Current Zoning: UR-2(CD) (Urban Residential, Conditional), N2-B (Neighborhood Residential)
Proposed Zoning: UR-2(CD) (Urban Residential, Conditional), UR-2(CD) SPA (Urban Residential, Conditional, Site Plan Amendment)

Approximately 7.01 acres located south of Alleghany Street, west of Ashley Road, and north of Bullard Street.

The petition proposes to amend a previously approved plan to allow a community of 123 single family attached dwelling units in the Ashley Park neighborhood.

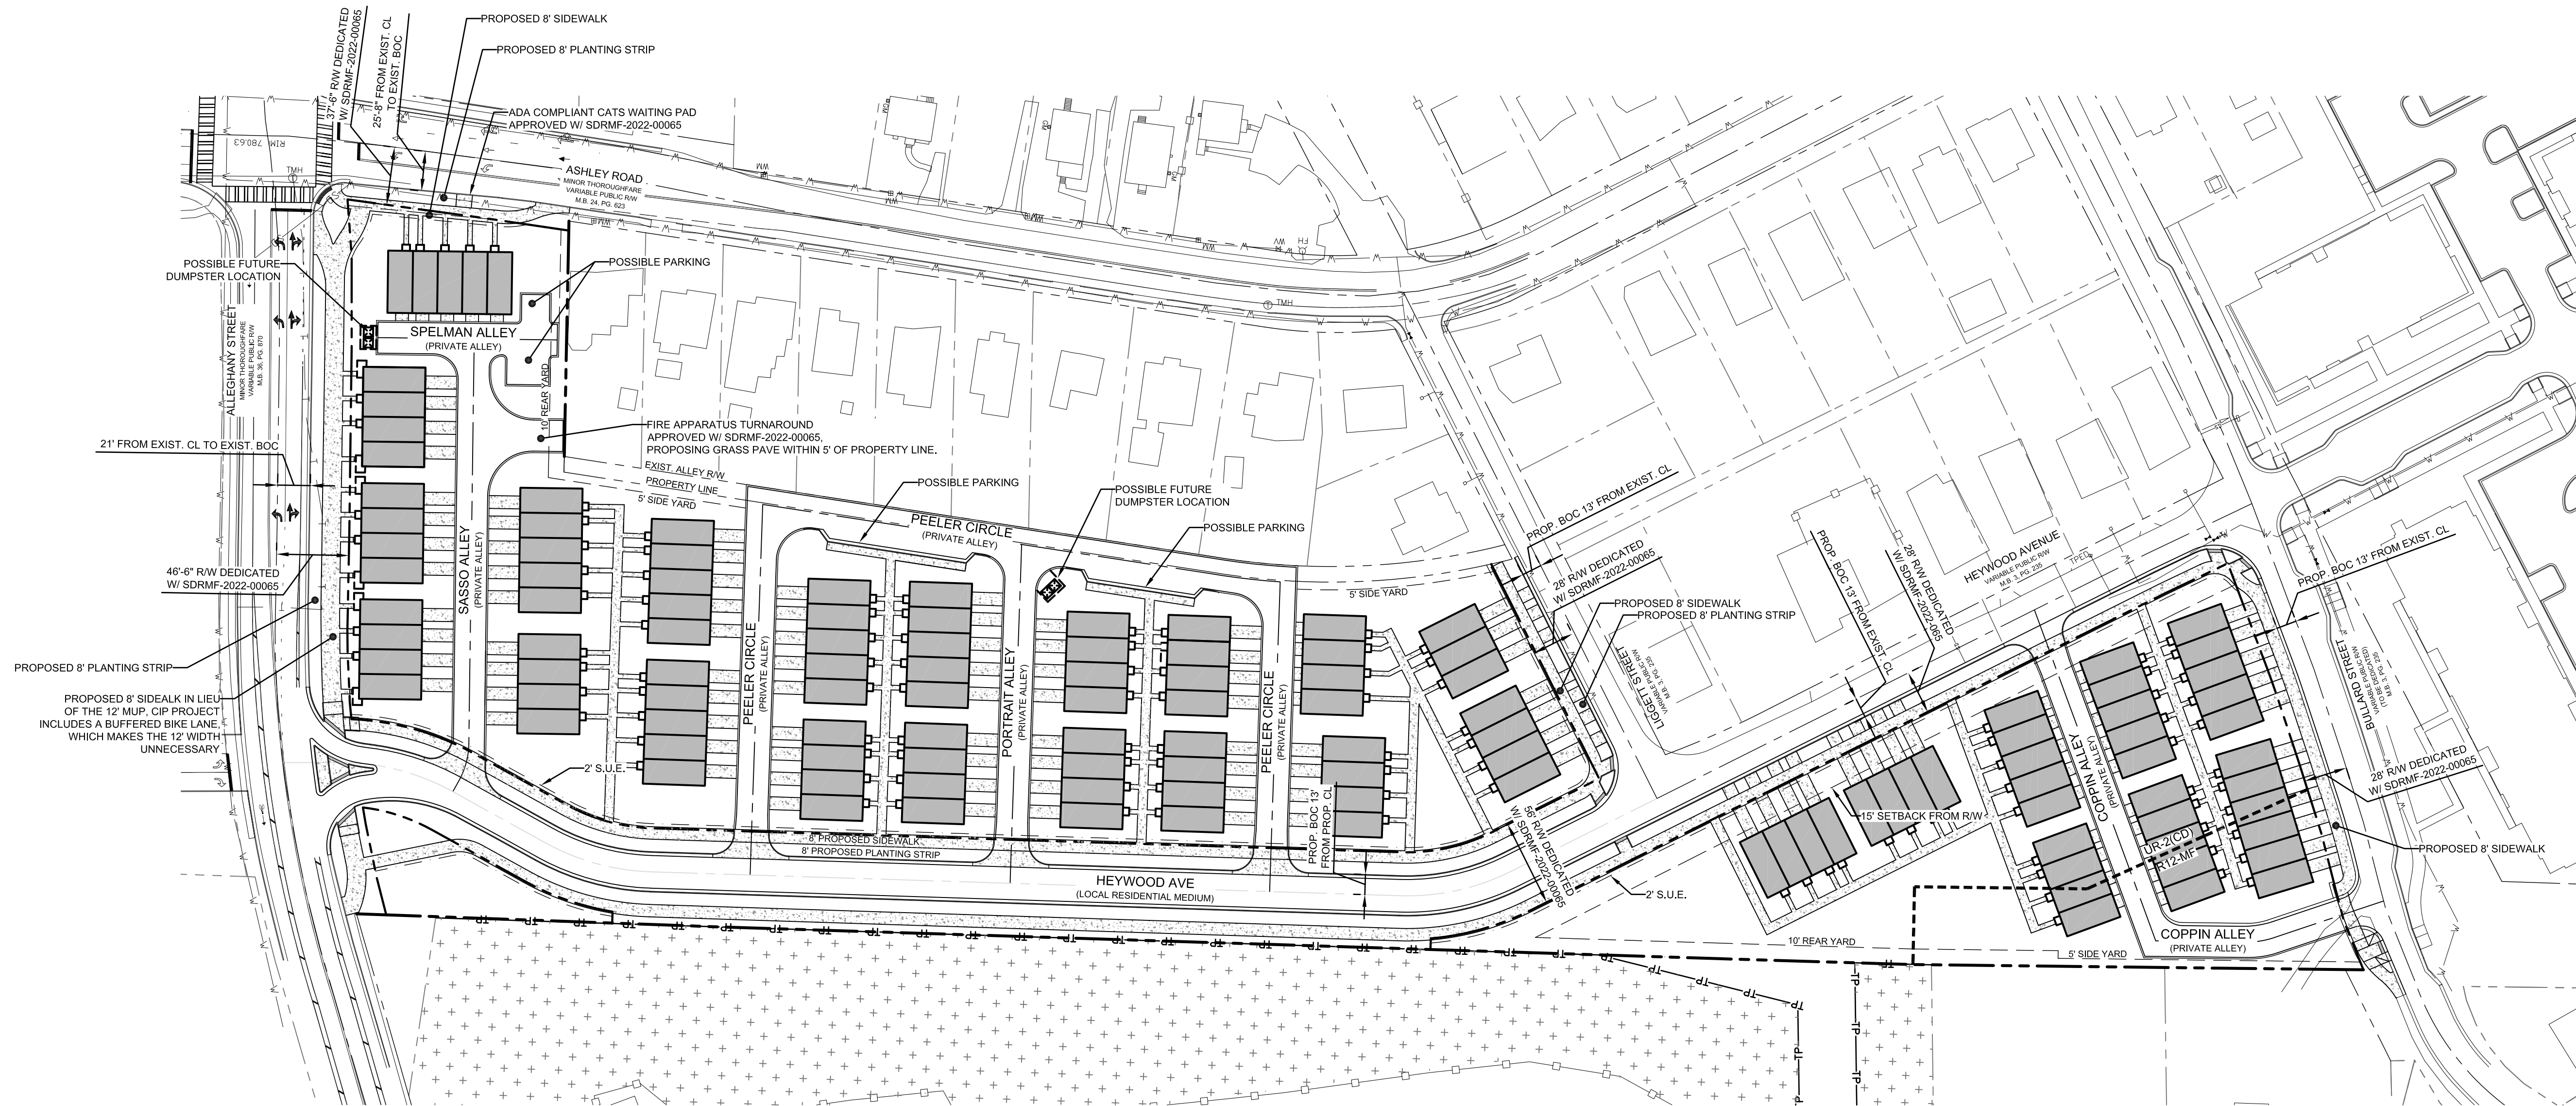
1. Label and dimension the future curb and gutter from the centerline for each road on the site plan. **OUTSTANDING**
2. ~~Add a conditional note specifying "A Right-of-Way Encroachment Agreement is required for the installation of any non-standard item(s) (irrigation systems, decorative concrete pavement, brick pavers, etc.) within a proposed/existing City maintained street right-of-way by a private individual, group, business, or homeowner's/business association. An encroachment agreement must be approved by CDOT prior to construction/installation. Contact CDOT for additional information concerning cost, submittal, and liability insurance coverage requirements."~~ **ADDRESSED**

3. Add a conditional note specifying "the Petitioner shall dedicate and convey in fee simple all rights-of-way to the City before the site's first building certificate of occupancy is issued. CDOT requests rights-of-way set at 2' behind back of sidewalk where feasible." **OUTSTANDING**

5. ~~Provide a tree survey identifying all trees of eight inch dbh or greater and all planted trees of two inch caliper or greater and six feet in height that grow partially or wholly within the city right-of-way.~~ **ADDRESSED**
6. Remove the last sentence of note IV.4 stating "None of these provisions shall apply when the ten (10) foot building separation requirement cannot be met if these improvements are made." **OUTSTANDING**
